Re: Project No. HL-11358-MAS/TKM  
FID No. 120572  
Good Hope Hospital  
Psychiatric Bed Expansion  
Erwin (Harnett)

The architectural portions of construction documents dated September 11, 2020 (received September 17, 2020) for the referenced project above have been reviewed for conformance with licensure rules for Hospitals (10A NCAC Chapter 13 Subchapter B). The architectural portions of the drawings are approved provided we receive satisfactory written responses and revised drawings that address the following comments:

1 FLOOR PLAN - NEW ADDITION

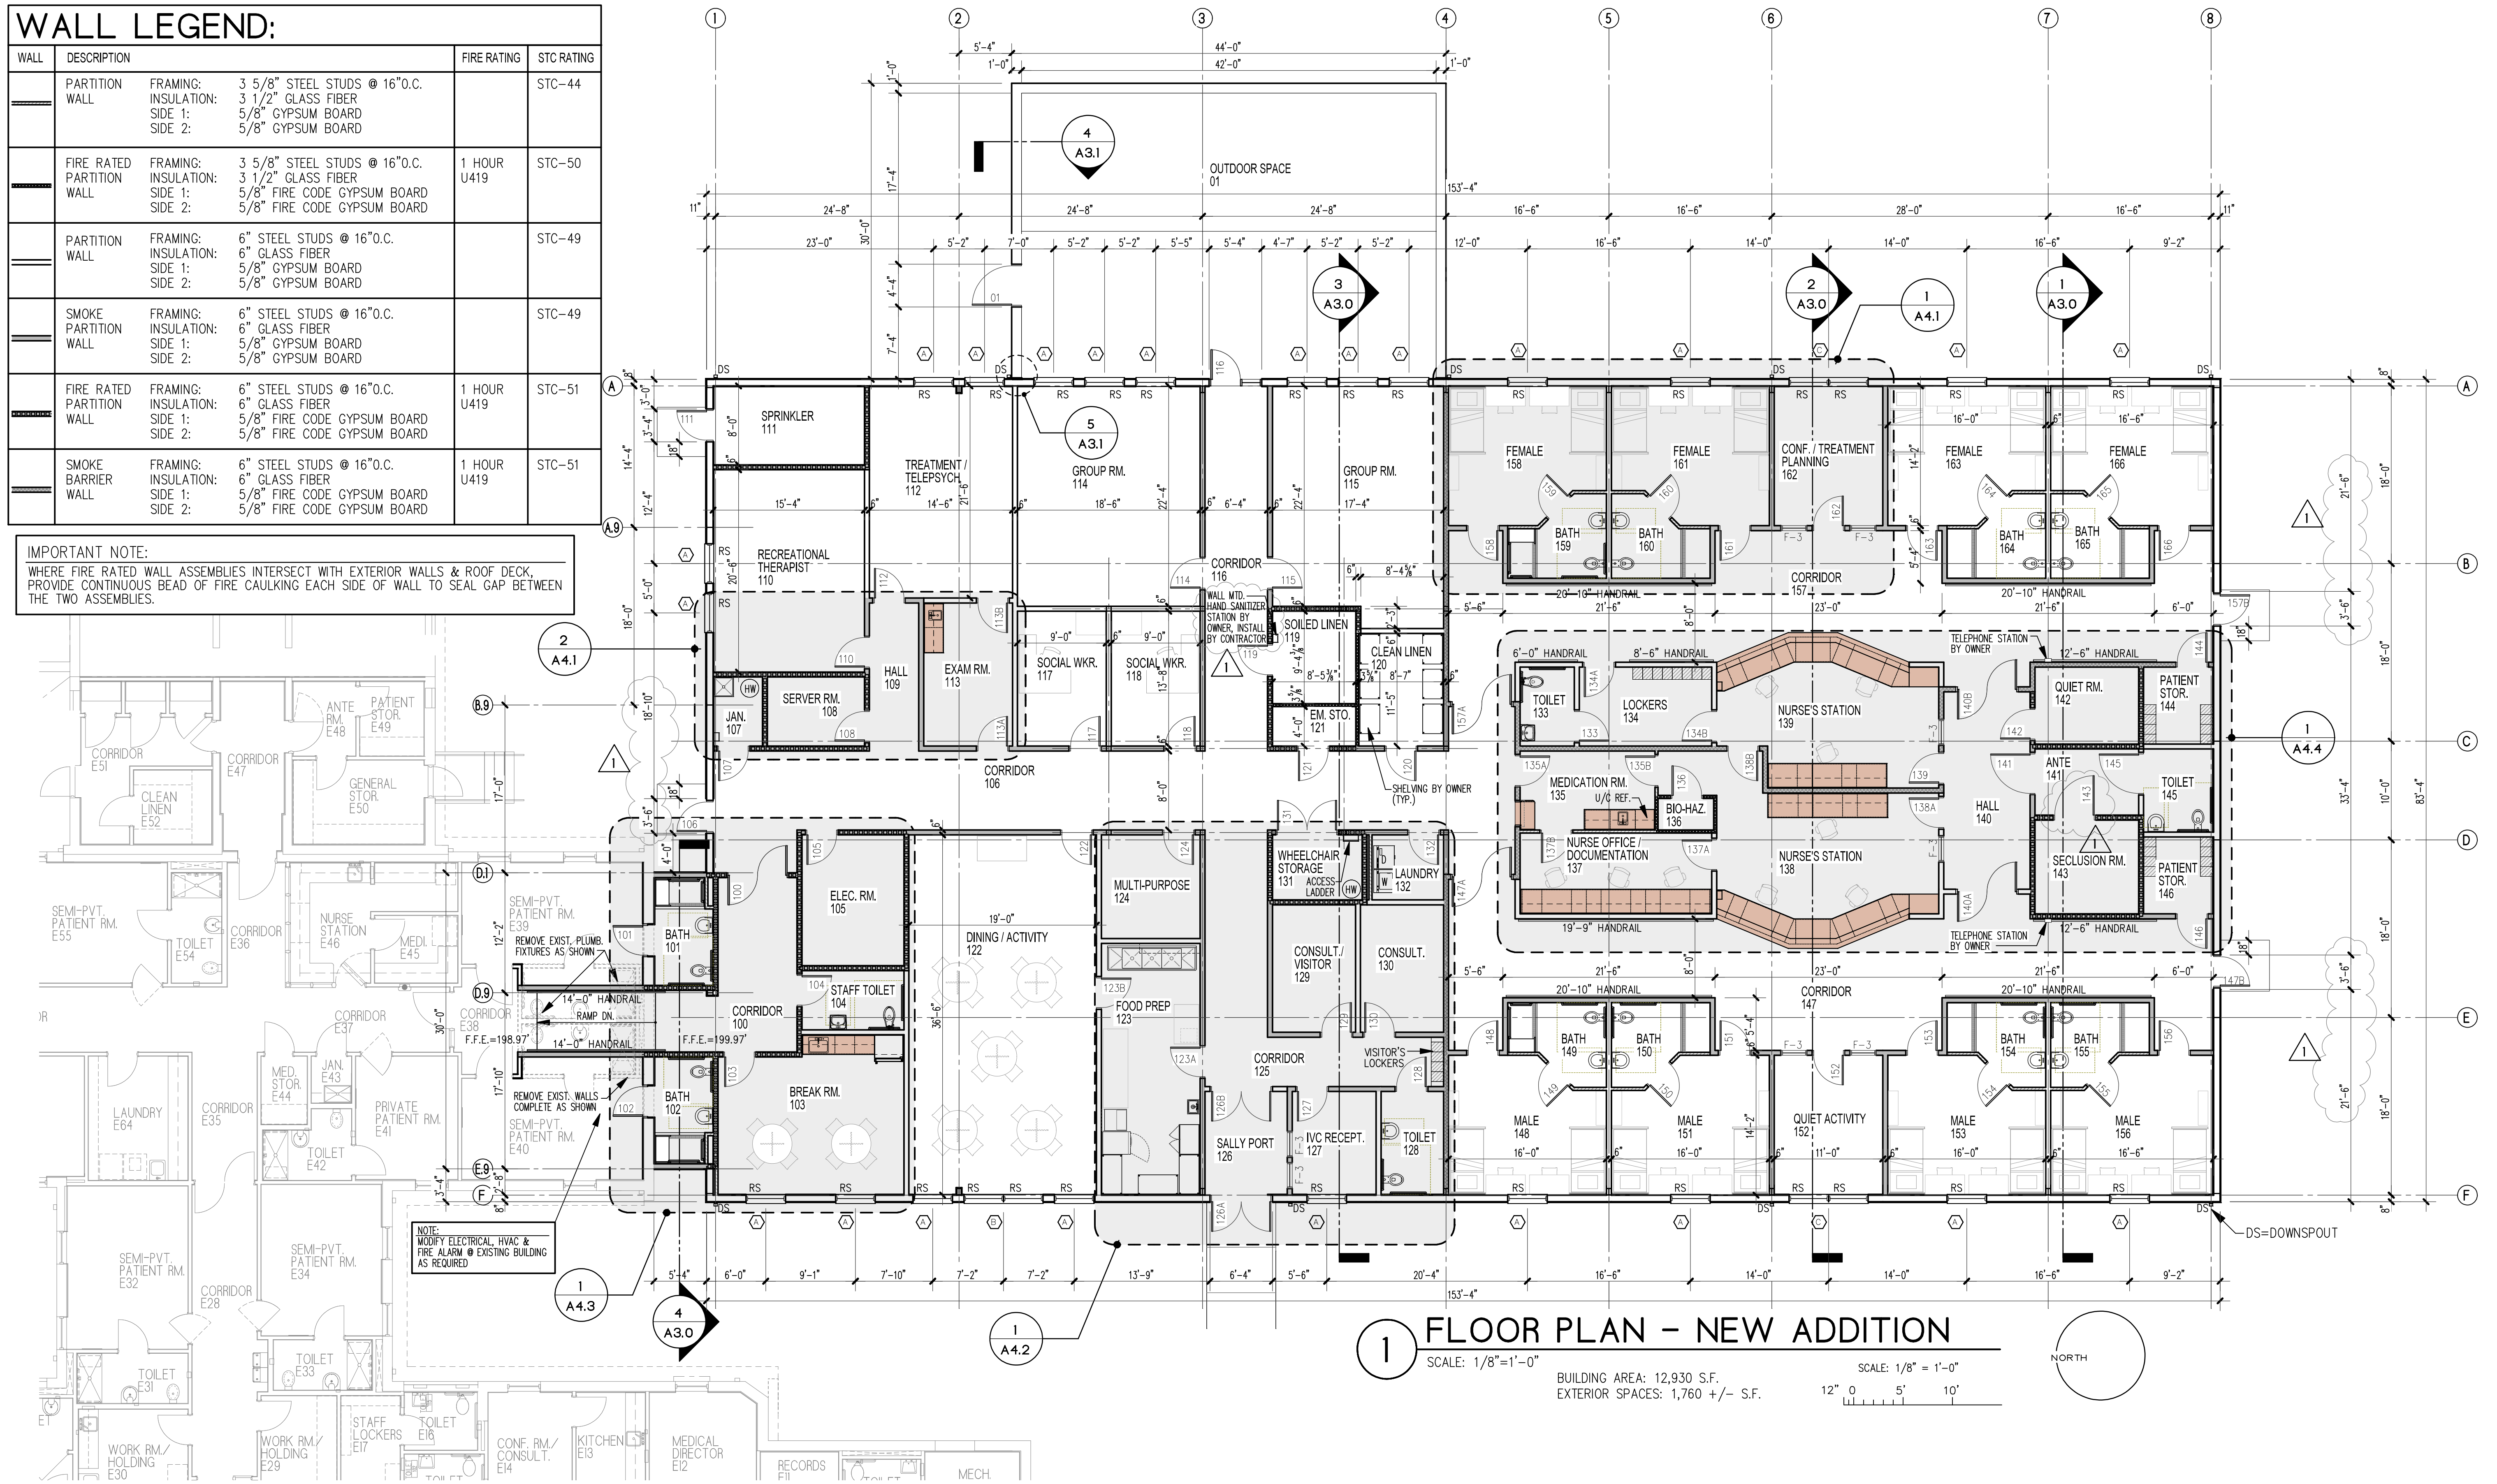
2. Confirm that the glass at the Seclusion Room door is impact resistant.
3. Confirm that there is secured storage in the Food Prep 123. [FGI Section 2.5-2.2.8.9(3)(b)]

4. Soiled Holding 119 must include a handwashing station or hand sanitizing station. [FGI Section 2.5-2.2.8.12 & 2.1-2.8.12.3(1)]
5. A hand Sanitizing station must be included in Jan 107. [FGI Section 2.5-2.2.8.14 & 2.1-2.8.14.2(3)]

7. Confirm that all sides of the smoke barriers in the attic will be accessible from the ceiling access hatches for inspection.
8. Confirm that all fire sprinklers, electrical receptacles, light fixtures, and other accessories are tamper and ligature resistant. [FGI Section 2.5-7.2.2.7]
9. Electrical Room 105 door is shown as not rated on the Door Schedule, but the room is 1-hour rated. The door must be 45-minute rated with closer.
10. Confirm that pair of Doors 131 to Wheelchair Storage include self-latching automatic flush bolts at the inactive leaf and smoke seals at the meeting edge to maintain the smoke resistant corridor wall. [NFPA 101 Section 18.3.6.3.8]
